FULL

Reference: H20-0417-25 **Date of Decision:** 27th June 2025
Applicant: Mr Coupe & Miss Roberts
17 Broadgate Road
Sutton St James
Spalding
Lincolnshire
PE12 0EL
Location: Markenville 17 Broadgate Road Sutton St James Spalding
Description: Demolition of conservatory & erection of single storey front & side extensions

PROJECT: PROPOSED SINGLE STOREY SIDE/FRONT EXTENSIONS	
DRAWING: PROPOSED FLOOR PLAN PROPOSED ELEVATIONS	
SIZE: A1	CLIENT: Mr A. Coupe & Miss Z. Roberts
SCALE: as labelled	DRAWING BY: JC
SHEET: 0479/25/02A

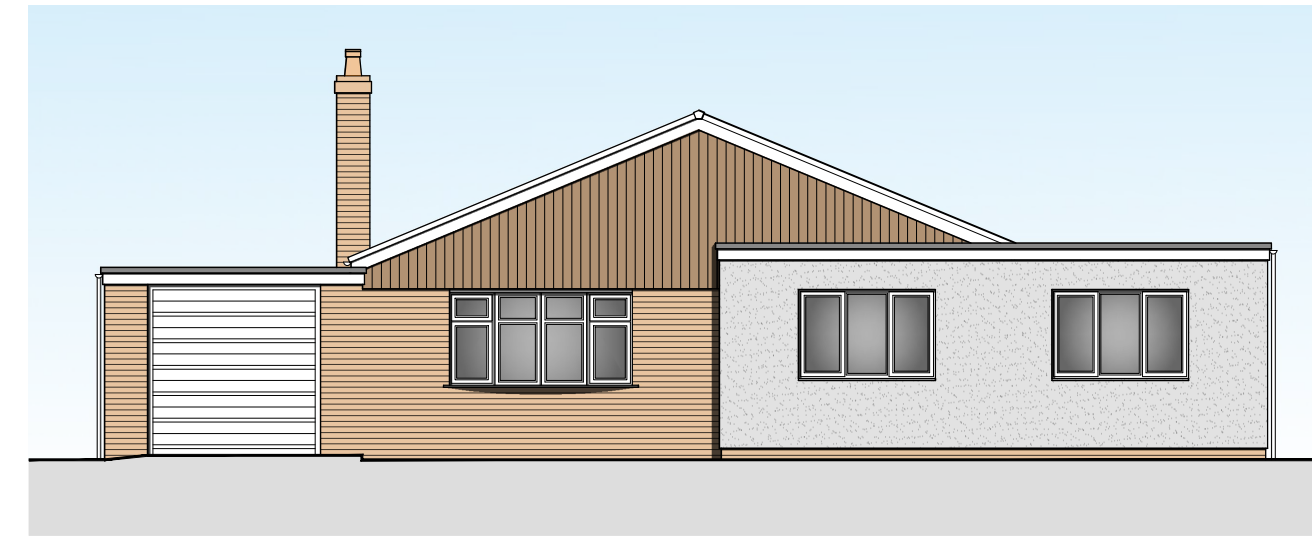
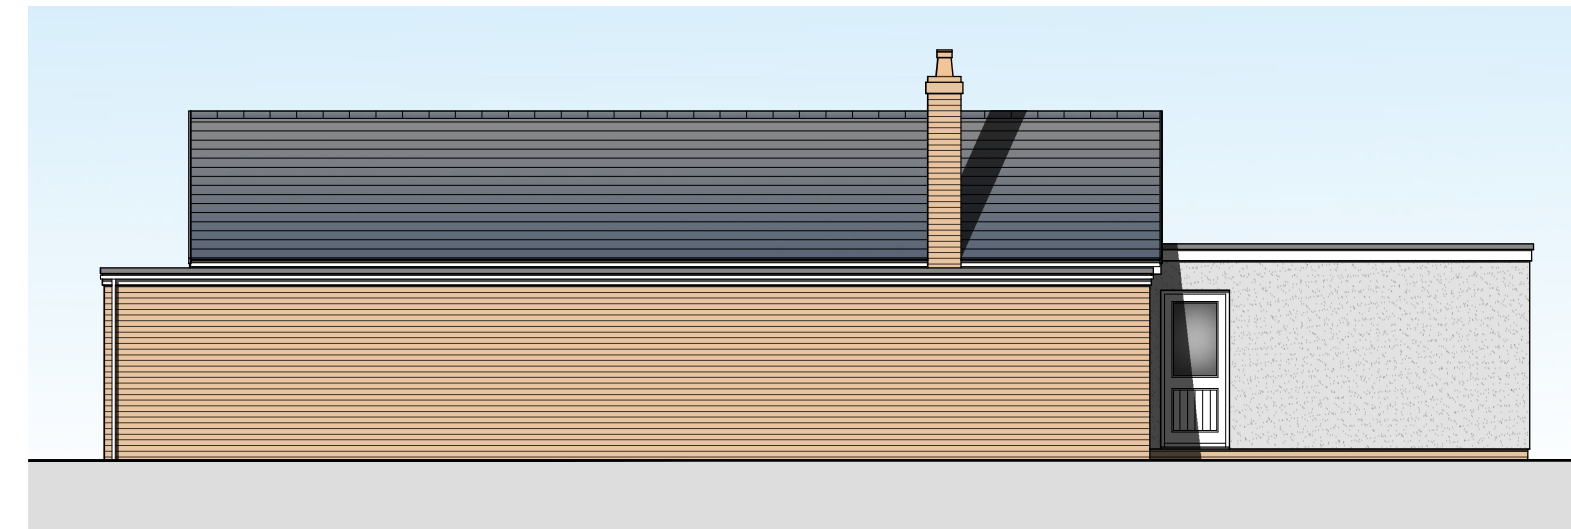
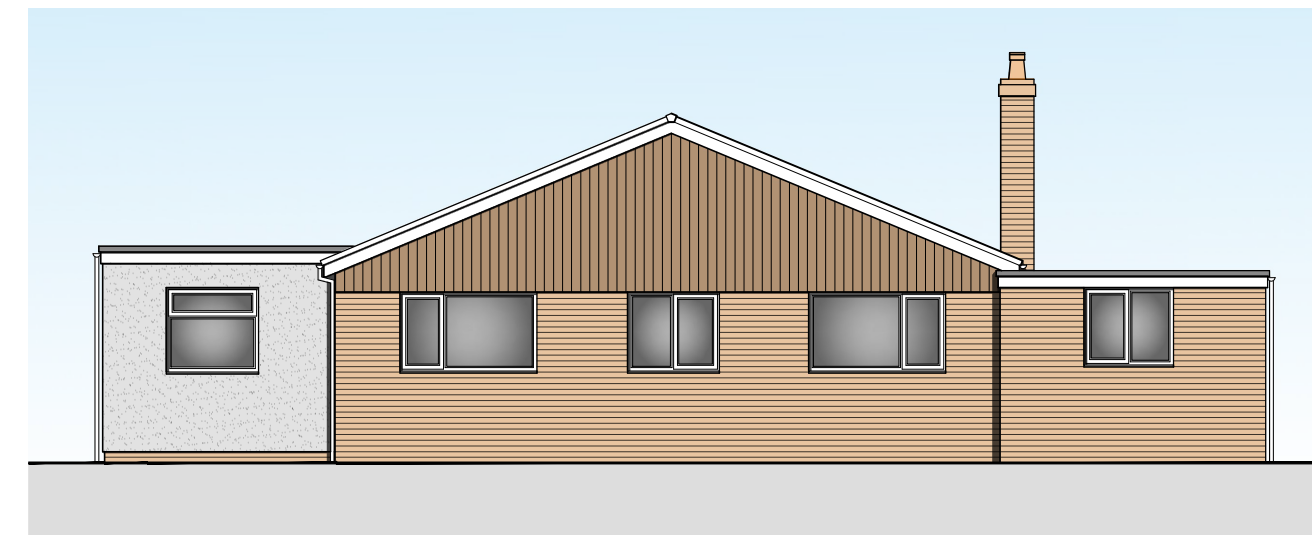
- 1 The proposed extensions would comprise an incongruent form of development within the street scene, and this would negatively impact the character and appearance of the area. The siting, scale and appearance of the proposed extensions represents poor design. As such, the proposed development is considered to be contrary to Policies 1, 2 and 3 of the South East Lincolnshire Local Plan (2019) and Section 12 of the National Planning Policy Framework (December 2024).
